RED ROCK RESERVE SUBDIVISION FILING 1B

A VACATION AND REPLAT OF LOTS 20 AND 21 RED ROCK RESERVE SUBDIVISION
A PORTION OF THE SOUTHEAST QUARTER OF THE SOUTHWEST QUARTER OF SECTION 8
TOWNSHIP 11 SOUTH, RANGE 67 WEST OF THE 6TH P.M.
EL PASO COUNTY, COLORADO

RRR 1B.DWG VIEW: REPLAT
NOVEMBER 22, 2017
PROJECT 17093
SHEET ___ OF ___

RRR 1B.DWG. VIEW: REPLAT
NOVEMBER 22, 2017
PROJECT 17093
SHEET 1 OF 1

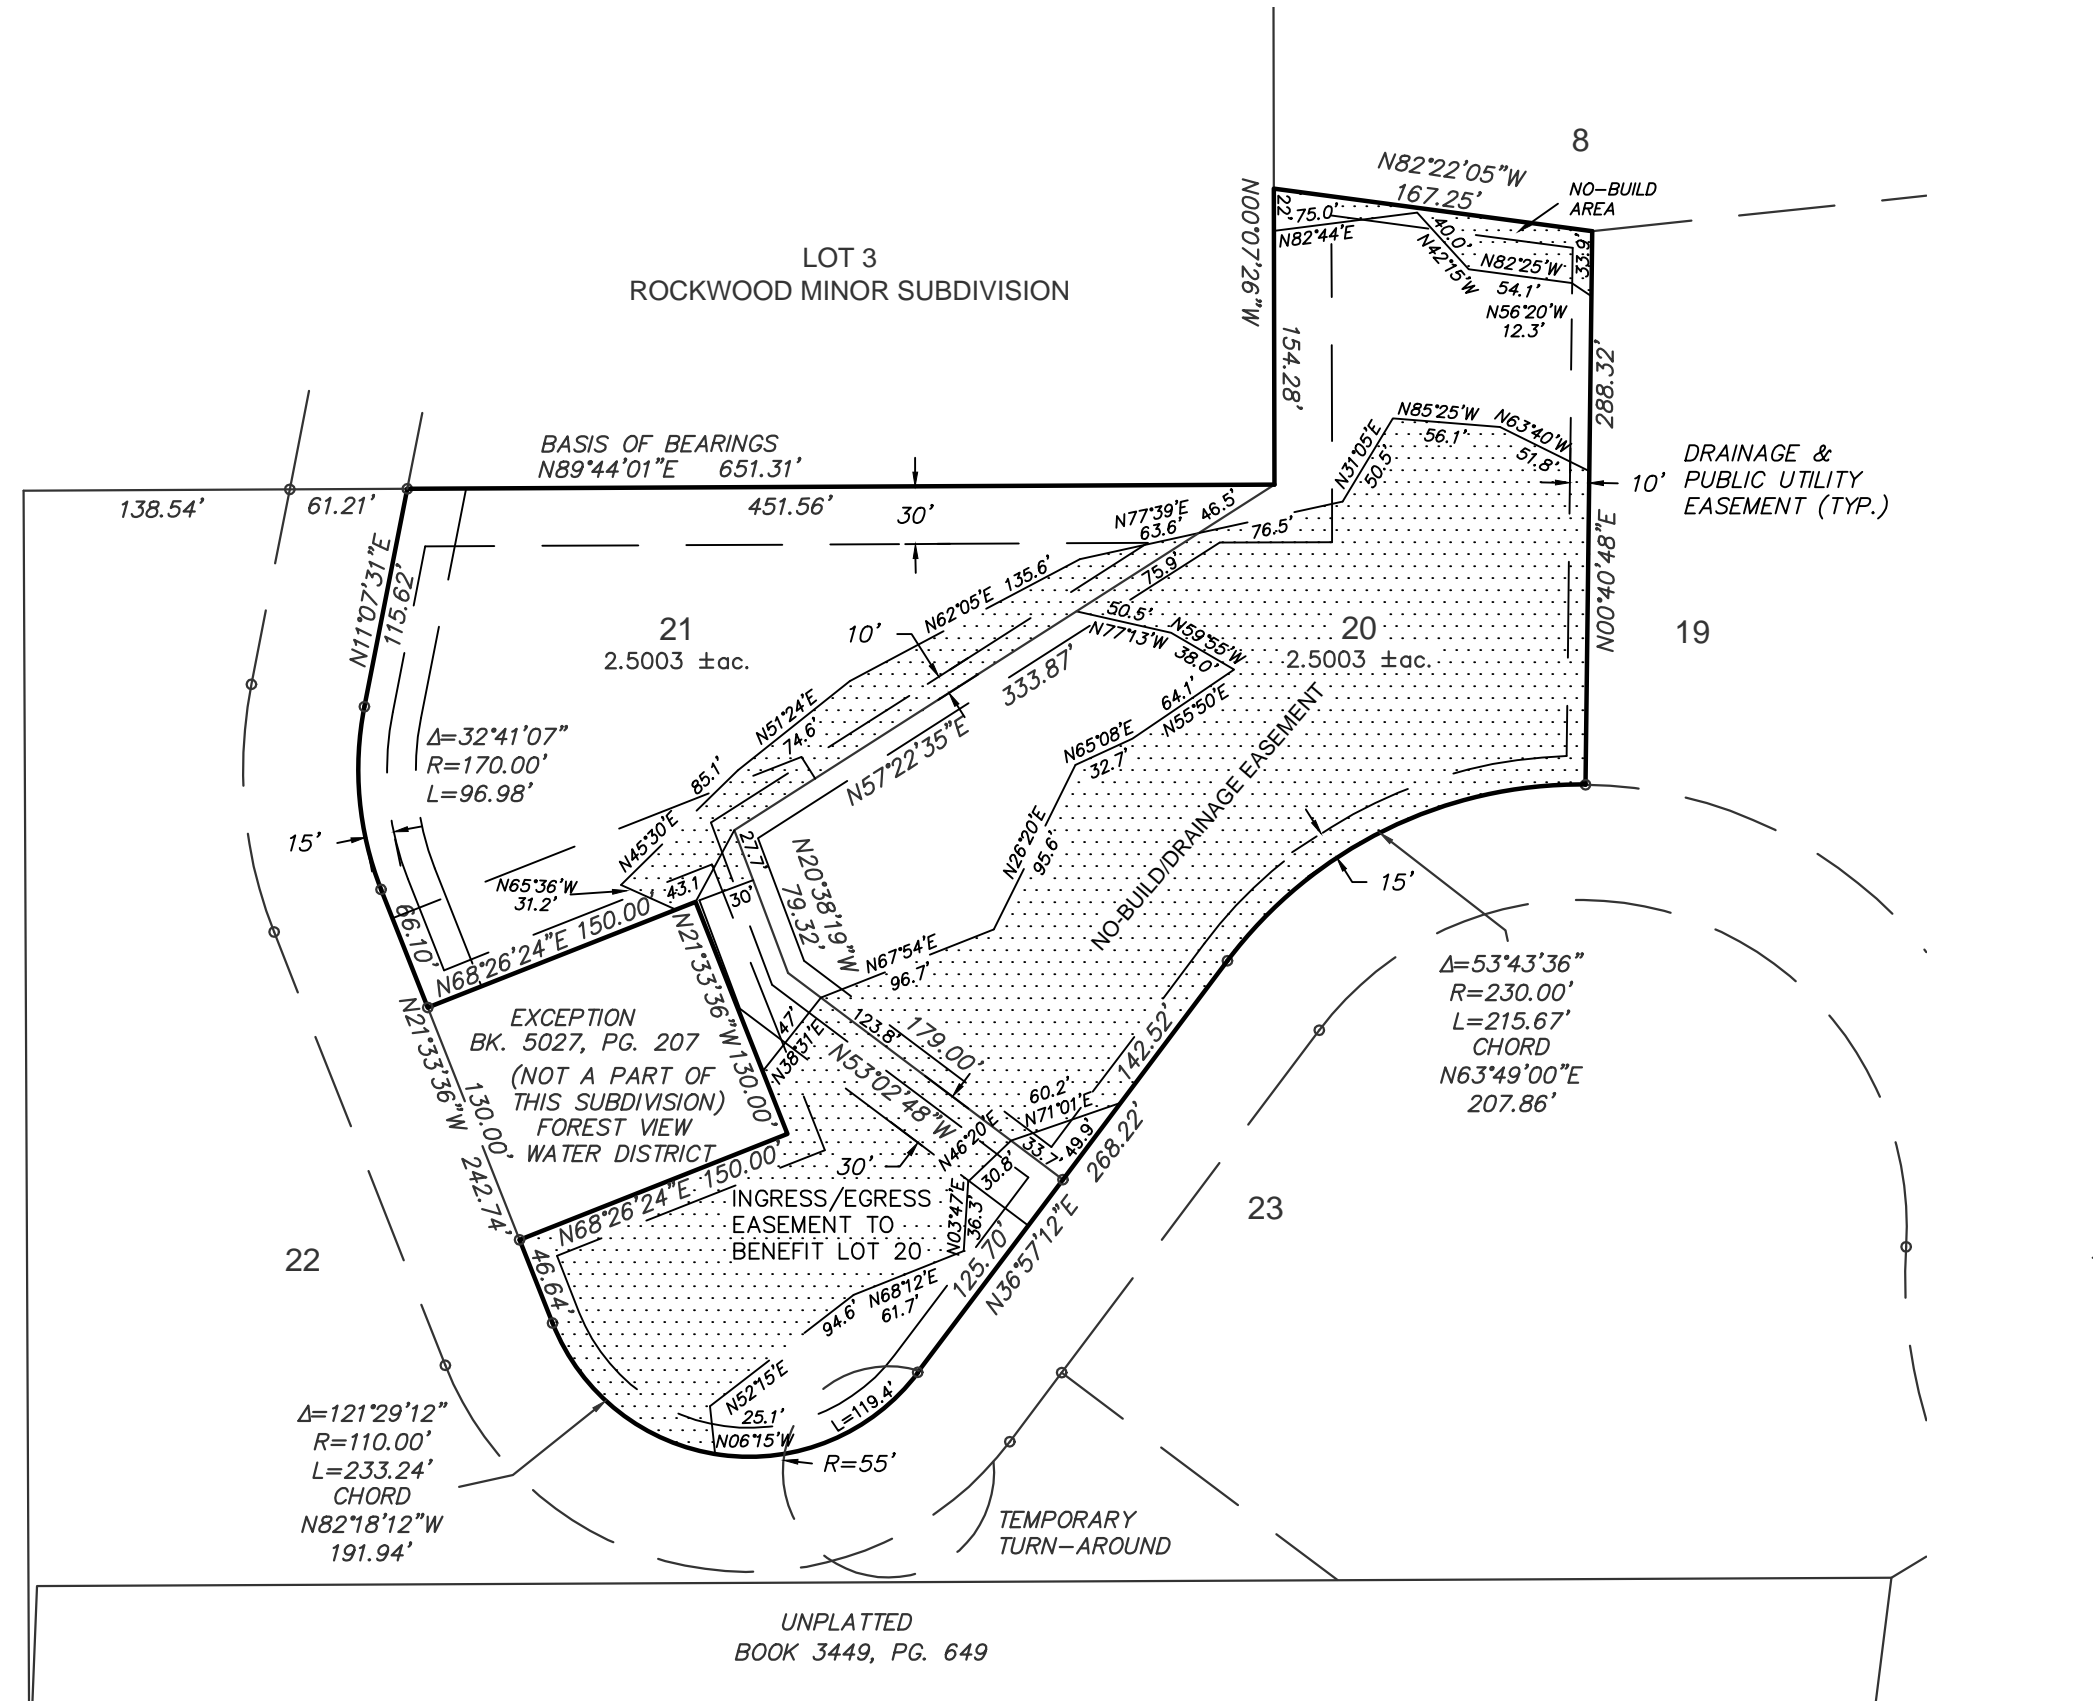
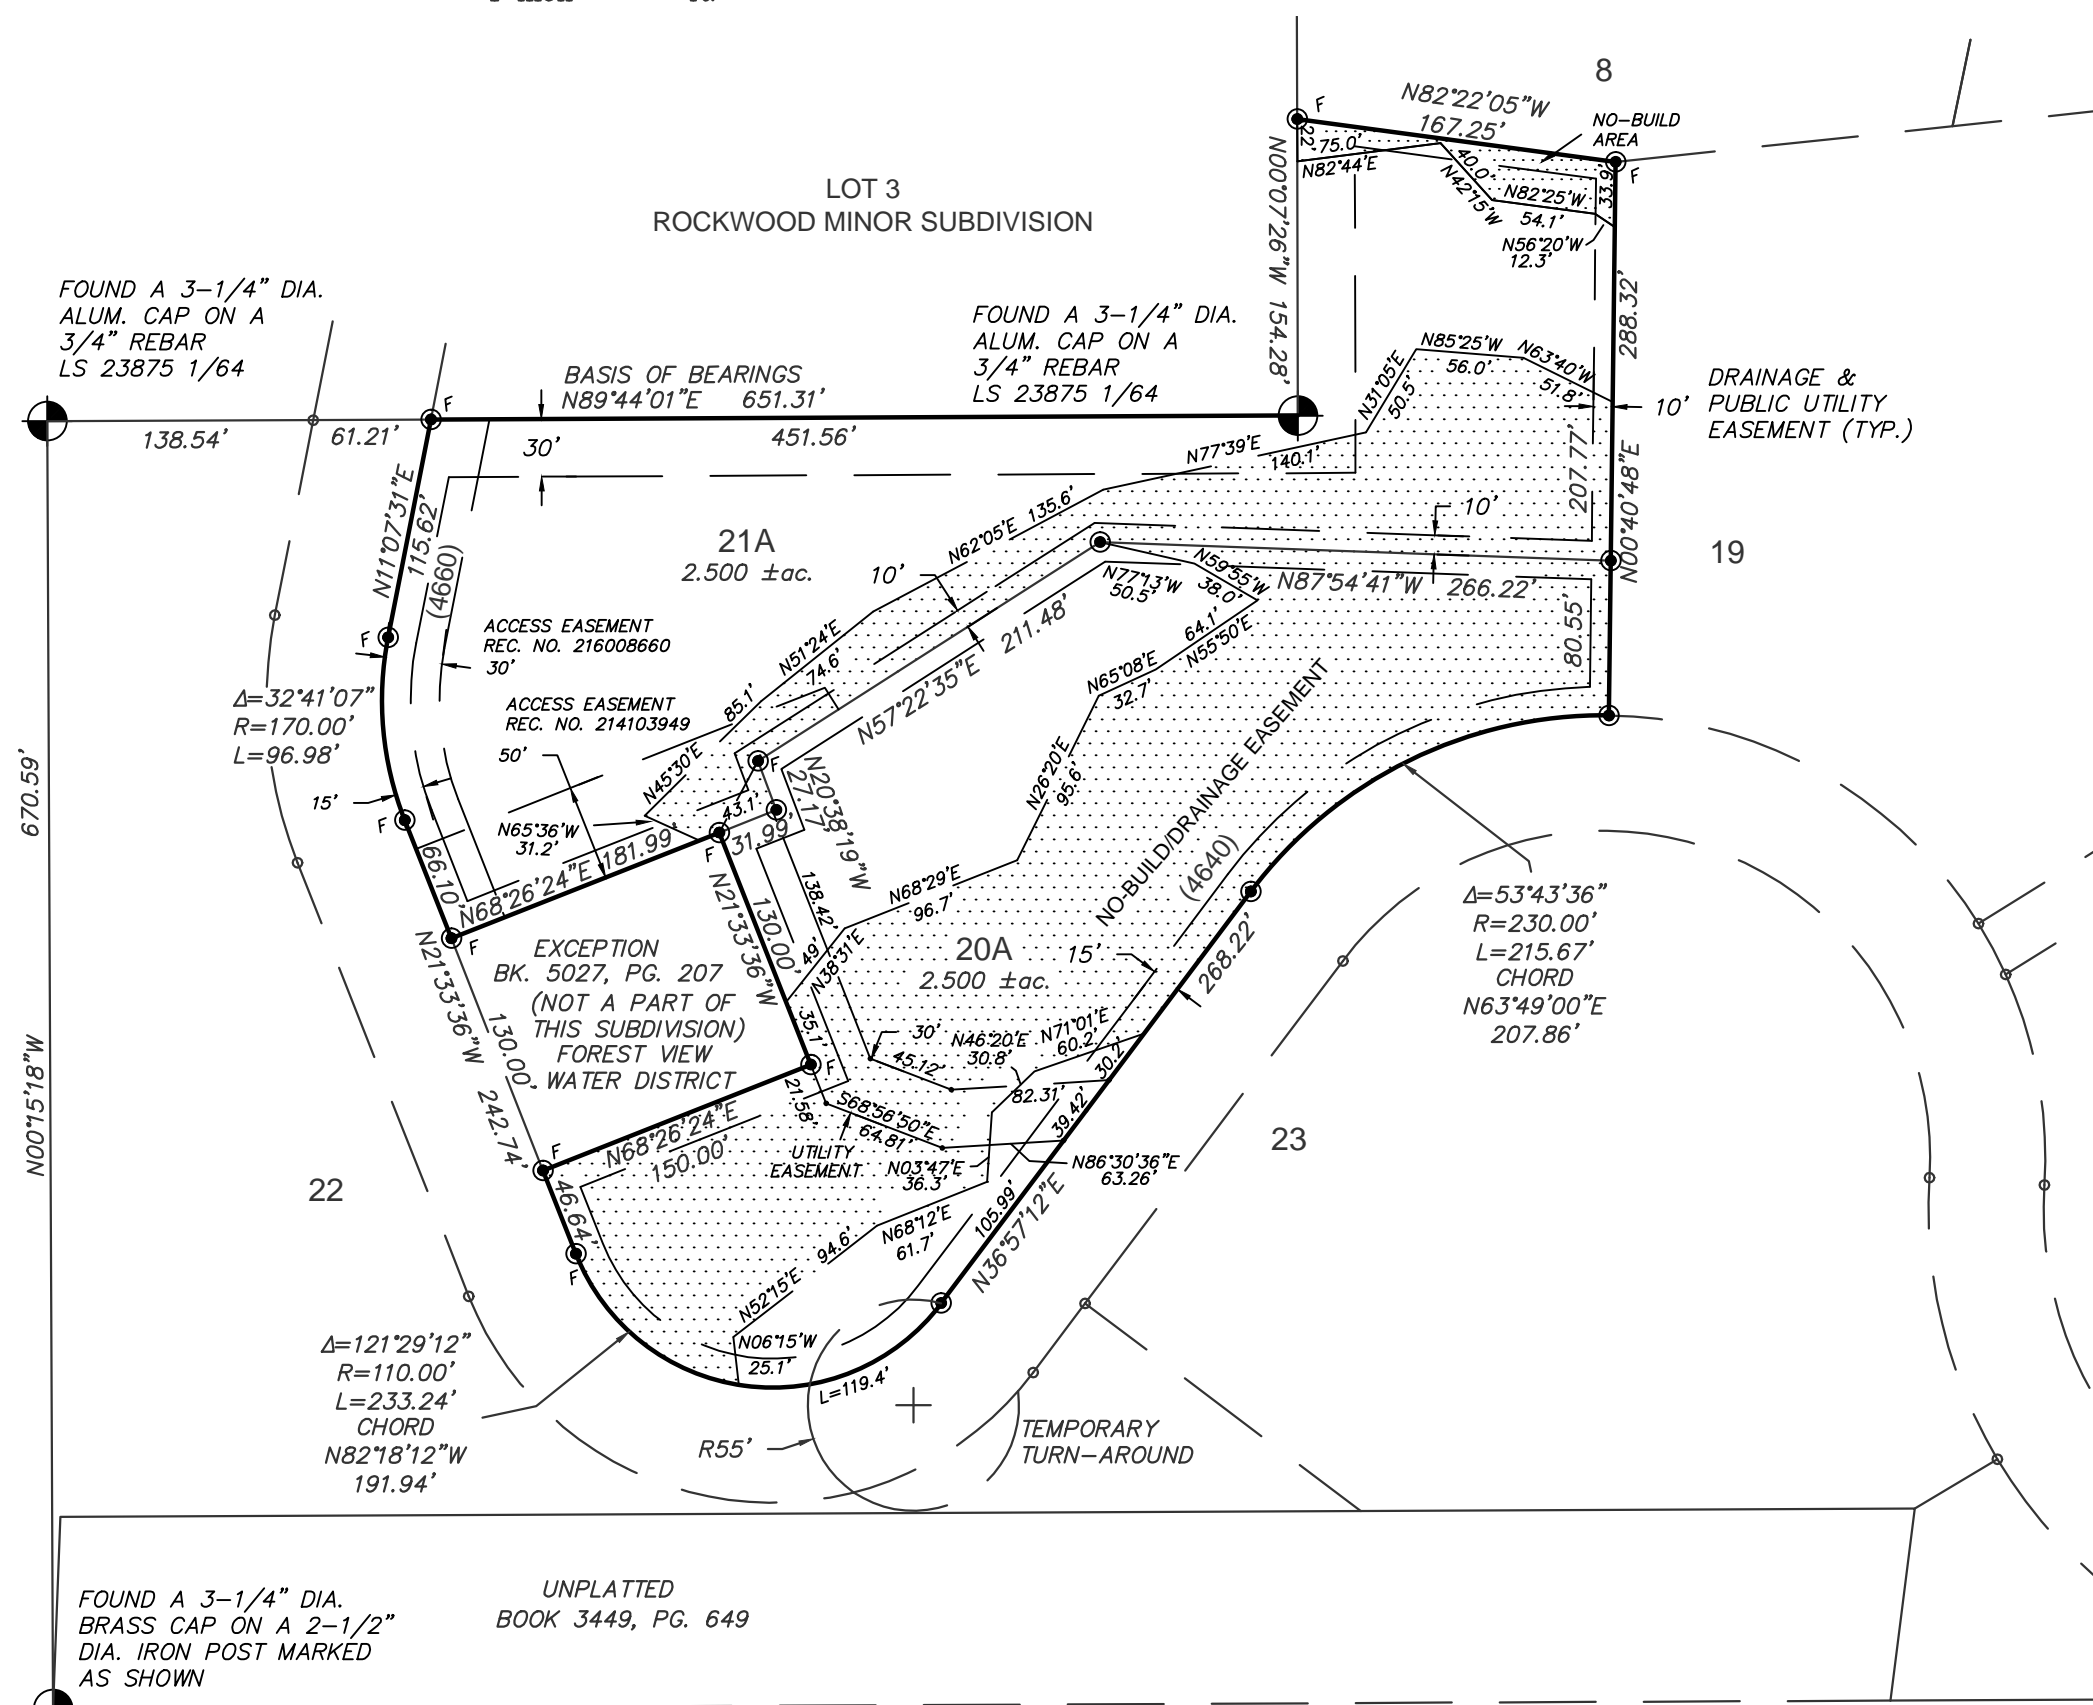
Number 13 of the Title Commitment is not addressed, Reception Number 203270170 needs to be added to the notes.

Whichever reception number(s) that correspond with the existing ingress, egress access or utility easement that is being proposed to change needs to be shown on a note that those reception numbers are to be vacated and replatted with a blank for the new reception number. Also, you will need to approach the utility companies to update their records for the new proposed easements.
